SICEEP, NORTH PLOT AND SQUARE (SSDA10) – CONSOLIDATED AGENCY RESPONSE TO SUBMISSIONS

**NORTH PLOT AND DARLING SQUARE
ACCESS AND LEVELS**

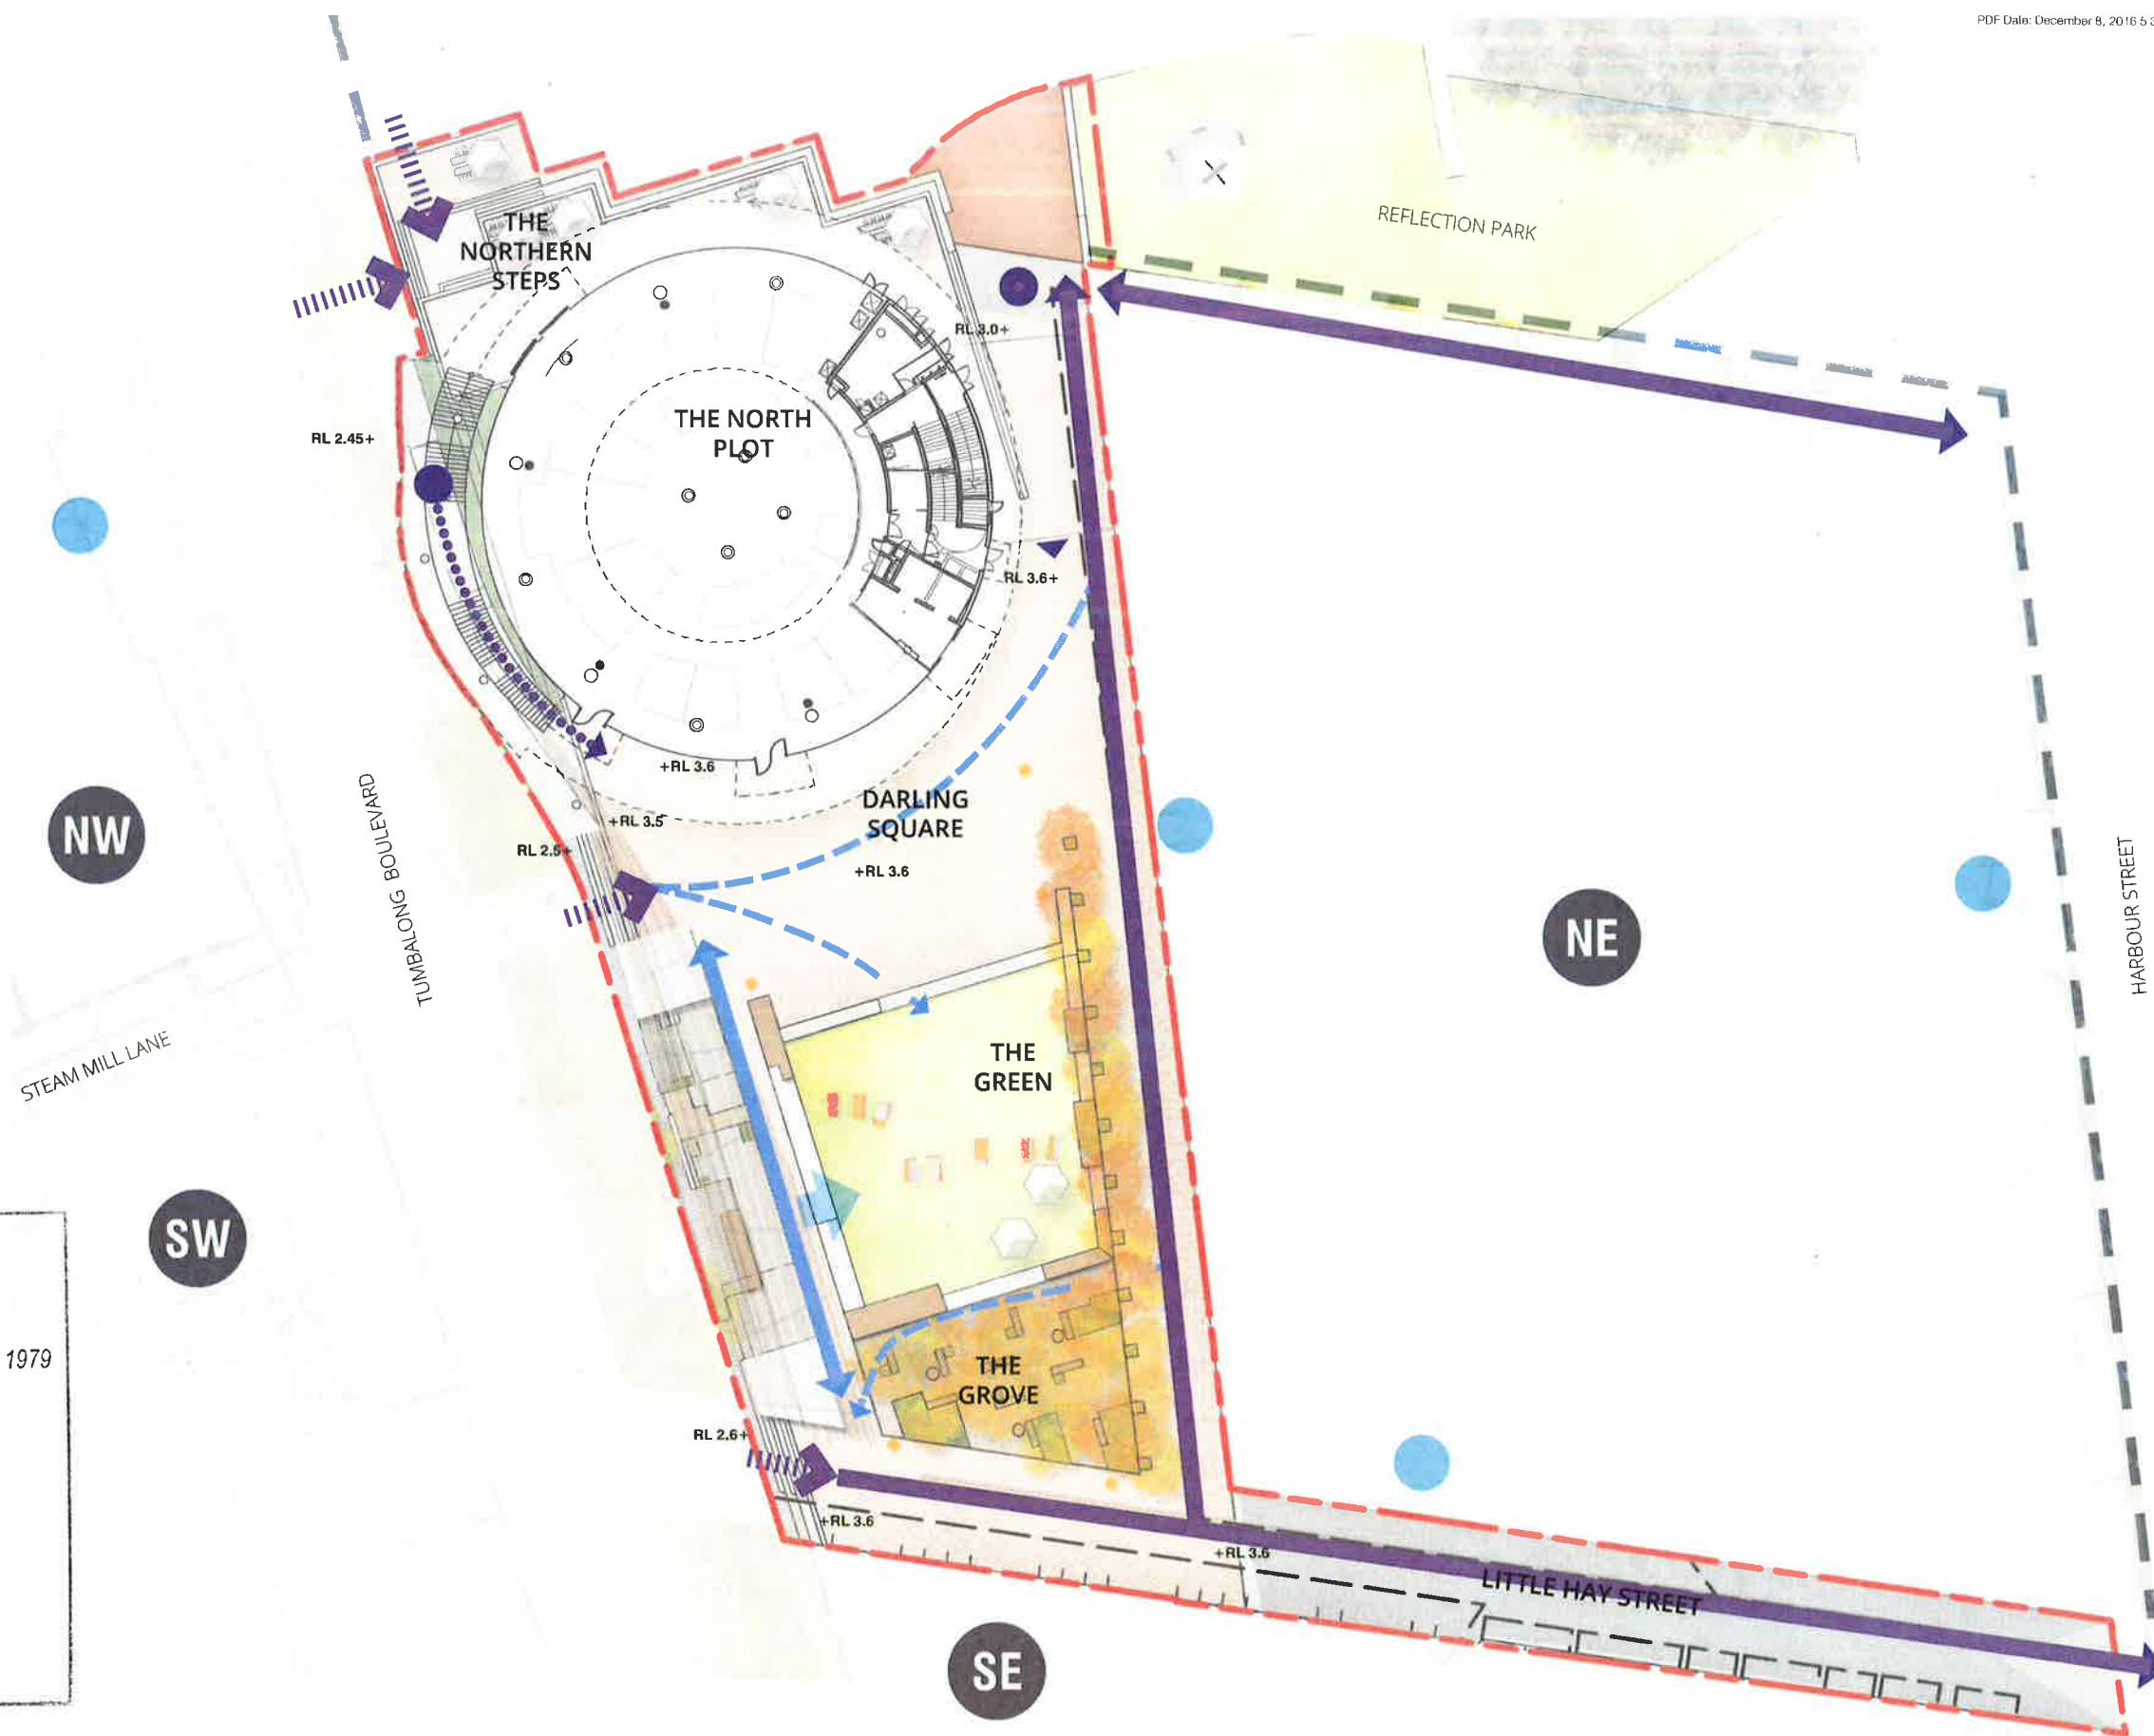
Key Issue	Response
unloading areas and confirm how pedestrian movement and safety will be safeguarded. Also confirm whether necessary landowner's consent has been obtained and what (if any) amendments are proposed to other development consents to facilitate the loading areas.	A range of loading locations remain and details of how these will be managed to ensure pedestrian movement and safety is safeguarded is discussed in detail in the Traffic Report Addendum (Appendix E of the Response to Submissions Report). Other loading/unloading areas within the precinct will include The Boulevard, Theatre Access Lane and Harbour Street. Loading/unloading activities for events within The Square will utilise The Boulevard and Theatre Access Lane. These are both owned by SHFA and landowners consent has been provided with the application, encompassing the use of these areas for loading/unloading. The use of the Harbour Street layover loading area will be in accordance with the restrictions placed on the location as part of future works approved under the North East Plot.

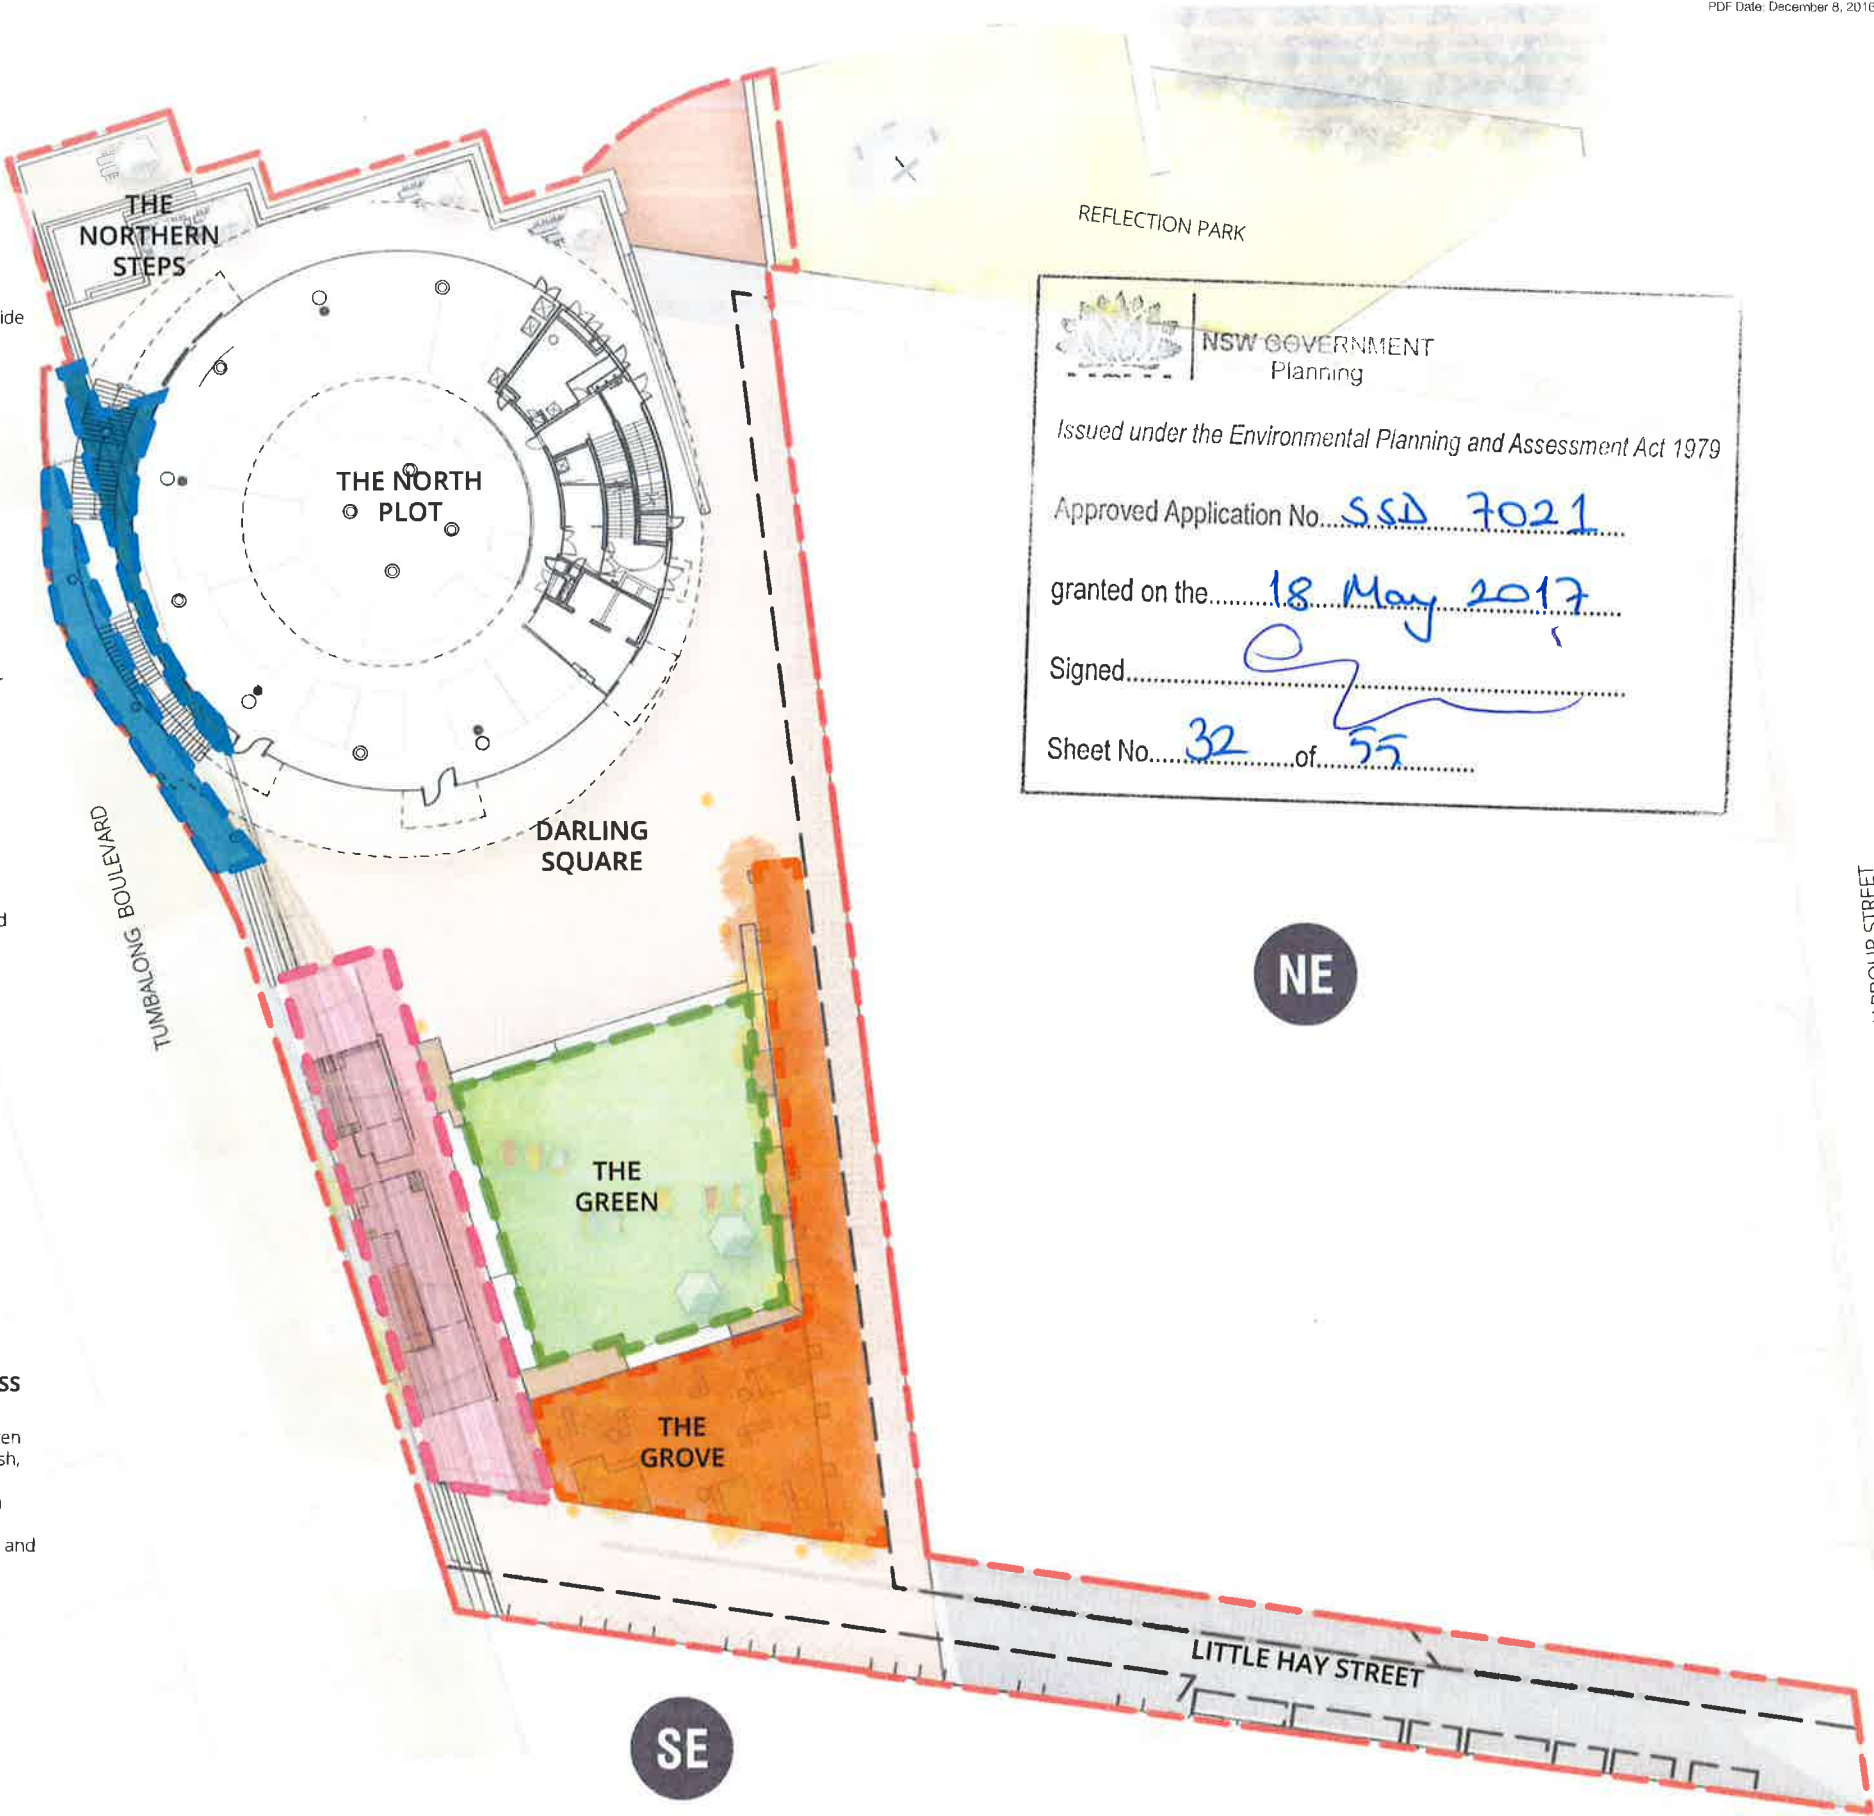
Justify the use of tree species Zelkova Serrata rather than an Australian/NSW native alternative.	This matter is discussed in the Supplementary Public Domain Design Report (Appendix D of the Response to Submissions Report).
Confirm whether the site area (4,600sqm) includes or excludes Little Hay Street.	It is clarified that the site area includes Little Hay Street. The site area has been increased to 4990m ² as outlined in the Supplementary Public Domain Design Report (Appendix D of the Response to Submissions Report) and covering Response to Submissions Report.
All applications	
Landowner's consent is required.	Landowners consent has been provided to the Department under separate cover.
